CITY OF ALBUQUERQUE

**Re: 3-Bay Oil Change (5400 Menaul)
5400 Menaul Blvd NE
Traffic Circulation Layout
Architect's Stamp 08-24-2021 (H18-D074)**

ENGINEER'S SEAL	3-BAY OIL CHANGE	DRAWN BY LN
	5400 MENAUL BLVD NE	DATE 08/26/2021
	TRAFFIC CIRCULATION LAYOUT	2021077-TCL
	TERRA WEST, LLC 5571 MIDWAY PARK PLACE NE ALBUQUERQUE, NM 87109 (505) 858-3100 www.tierrawestllc.com	SHEET # C1 JOB # 2021077

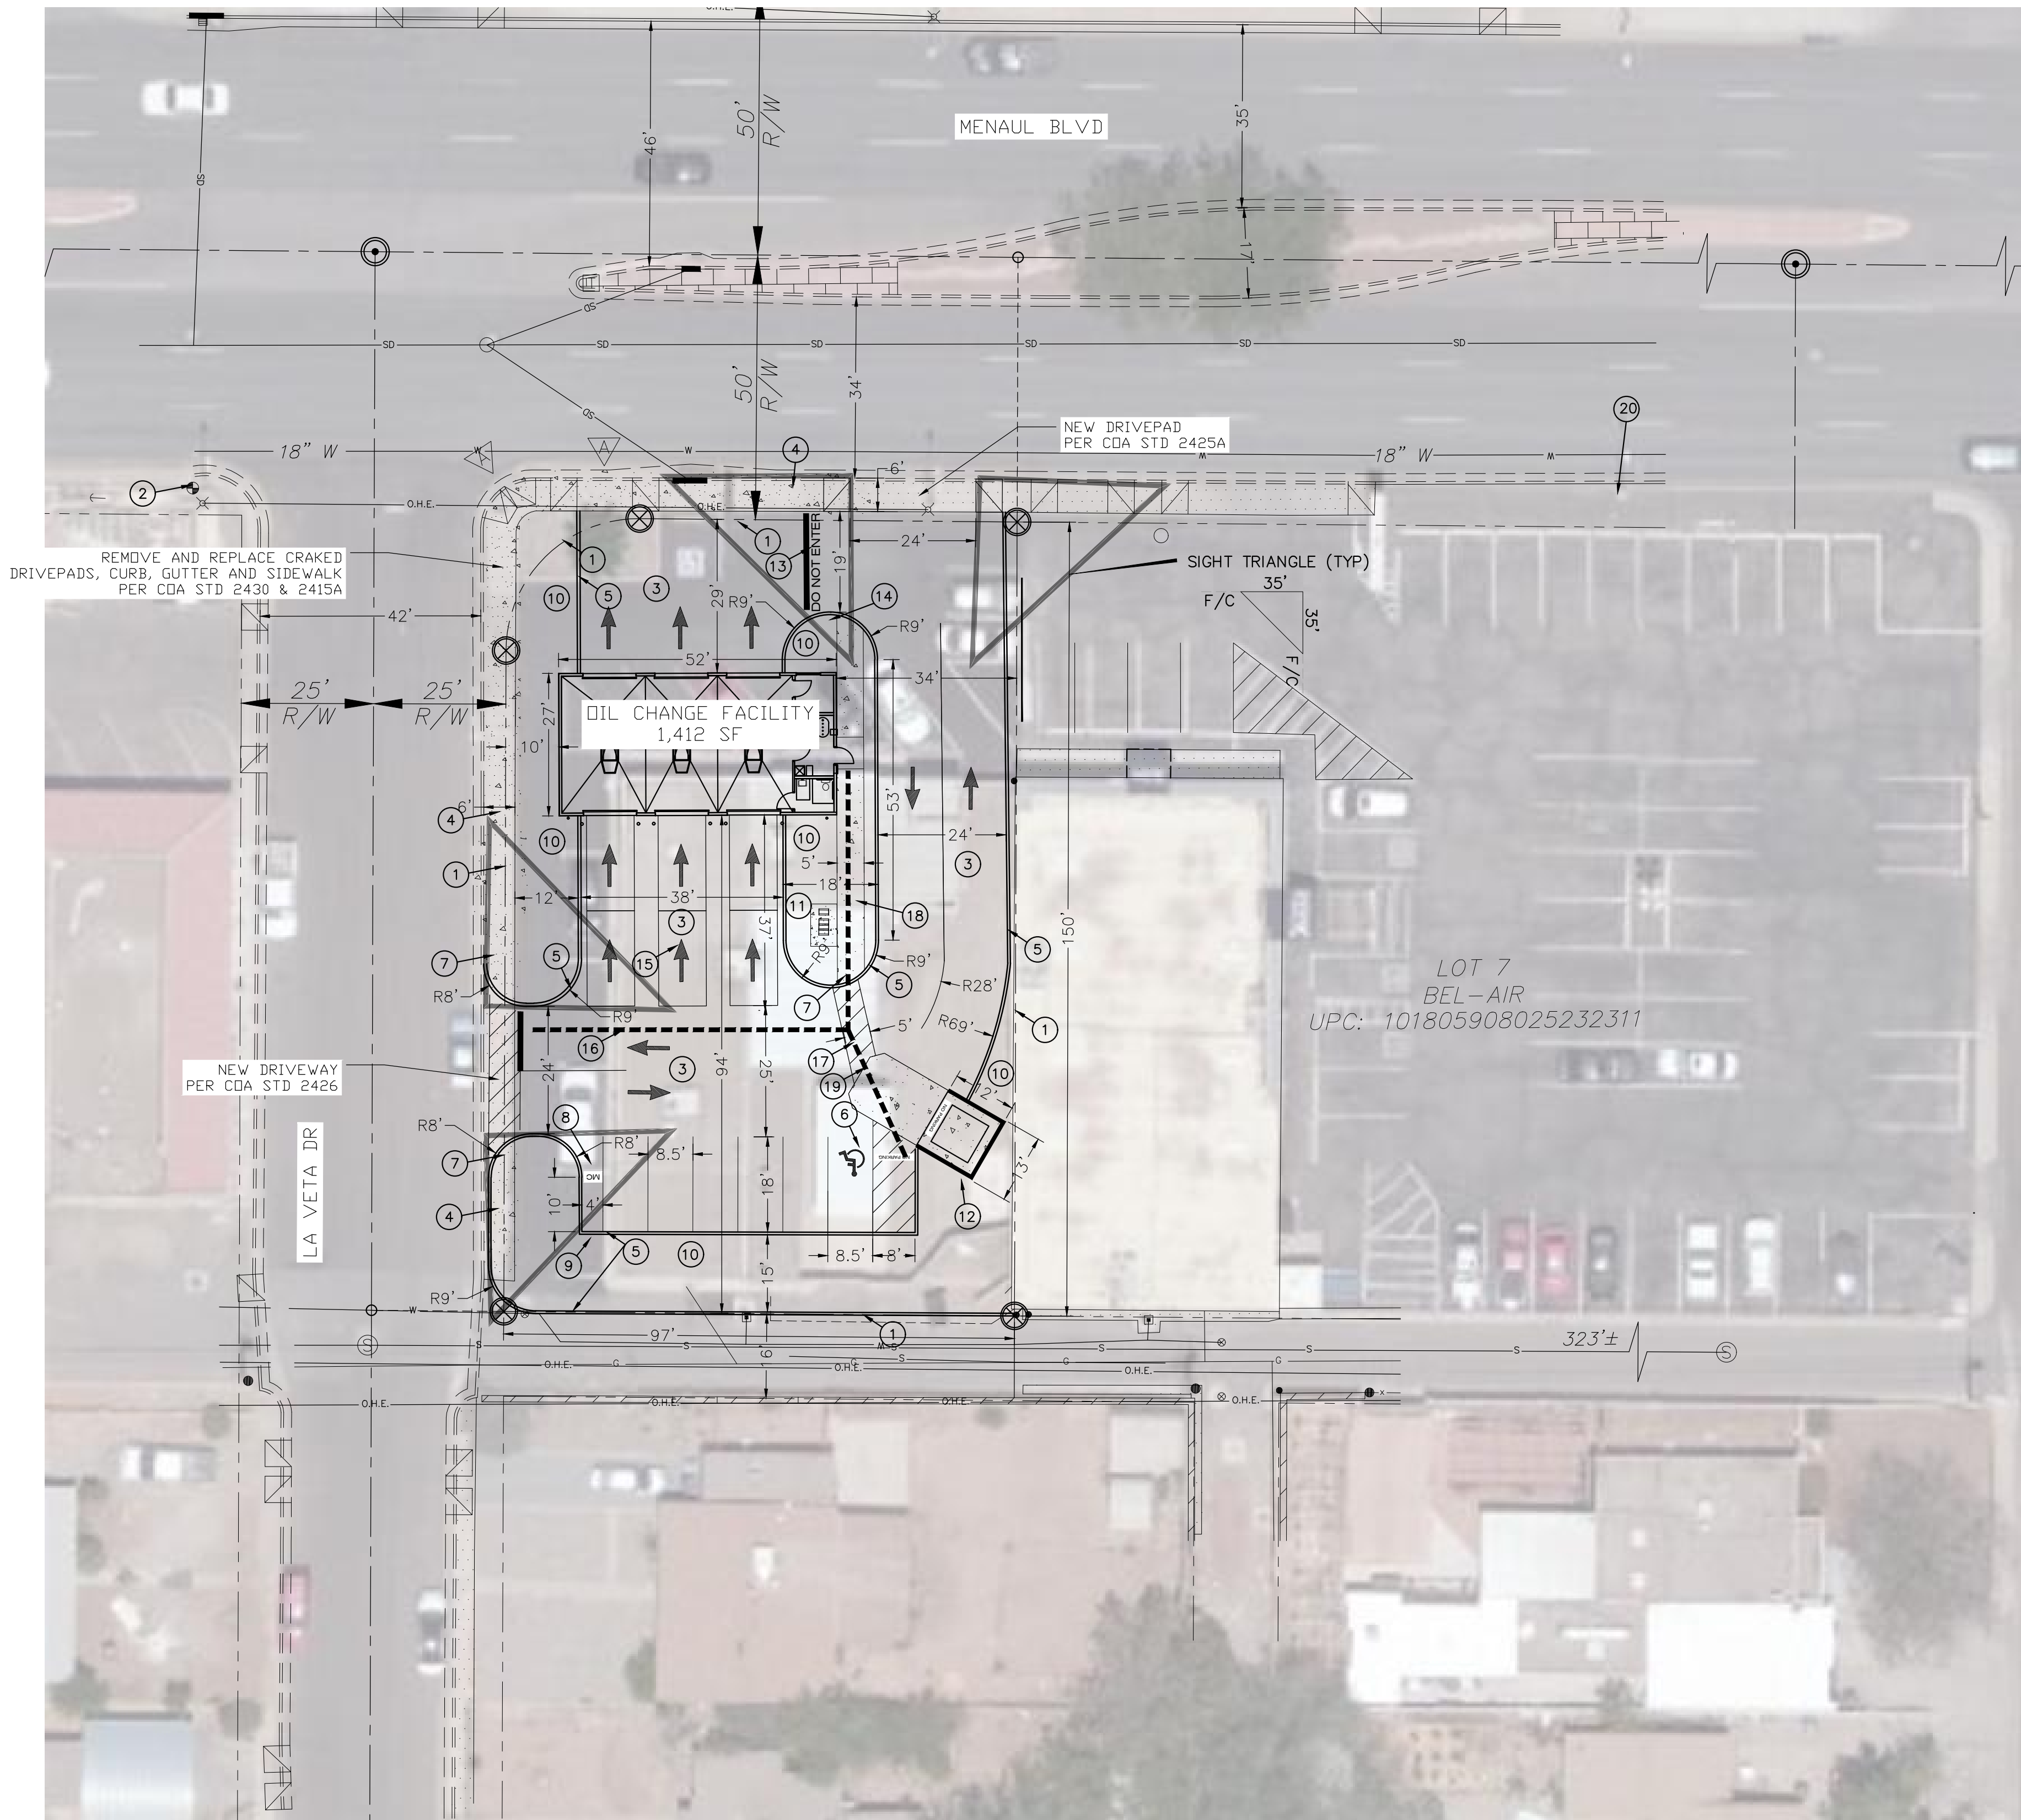
1. Listed are the number of parking spaces required by the IDO as well as the proposed number of parking spaces including bicycle and motorcycle parking.
Coordinate/discuss with Zoning.
2. **Sheet C3:** A crosswalk/ped crossing detail is shown on proposed Site Plan. Please clear up this concern.
3. **Keyed Note 16:** Proposed Public ADA accessible pathway is in conflict with vehicle traffic movement on drive aisle. This is a safety hazard and will not be allowed. Please provide an separate ADA route for pedestrian pathway from public sidewalk.
4. **FD approval will be needed for the proposed circulation layout.**
5. Identify all existing access easements and rights of way width dimensions.
6. **ADA curb ramps must be updated to current standards and have truncated domes installed at the corner La Veta Dr/Menaul, and alley way entrance.**

9. A 1-foot clear zone around the bicycle parking stall shall be provided.
10. Bicycle parking spaces shall be at least 6 feet long and 2 feet wide.
11. Per the IDO, a **6 ft. wide ADA accessible pedestrian pathway is required from the public sidewalk to the building entrances.** Please clearly show this pathway and provide details.

12. Per DPM, a **6 ft. wide ADA accessible pedestrian pathway is required from the ADA parking stall access aisles to the building entrances.** Please clearly show this pathway and provide details.

13. **Provide a copy of refuse approval.**
14. All one-way drives shall have "One Way" **signage** and pavement markings. **Please show detail and location of posted signs and striping.**

15. **The minimum drive through lane width is 12 feet with a 25 foot minimum radius (inside edge) for all turns.** (A 15 foot radius can be used with an increase in lane width to 14 feet). **The individual lanes will need to be dimension.**

16. Please provide a sight distance exhibit (11'x11'). **A sight triangle of 35' x 35' will need to be provided at corner of La Veta/Menaul.**
17. Show the clear sight triangle and add the following note to the plan: **"Landscaping and signage will not interfere with clear sight requirements. Therefore, signs, walls, trees, and shrubbery between 3 and 8 feet tall (as measured from the gutter pan) will not be acceptable in the clear sight triangle.**

18. **Shared Site access:** driveways that straddle property lines, or are entirely on one property but are to be used by another property, shall have an access easement. Please include a copy of your shared access agreement with the adjacent property owner.

19. **Unused curb cuts must be replaced with sidewalk and curb & gutter.** A build note must be provided referring to the appropriate City Standard drawing (2430 & 2415A) **for driveway off Menaul closes to intersection of side street.**

20. Add a note stating "All broken or cracked sidewalk must be replaced with sidewalk and curb & gutter." A build note must be provided referring to the appropriate City Standard drawing, **includes Menaul existing sidewalk and curb & gutter.**
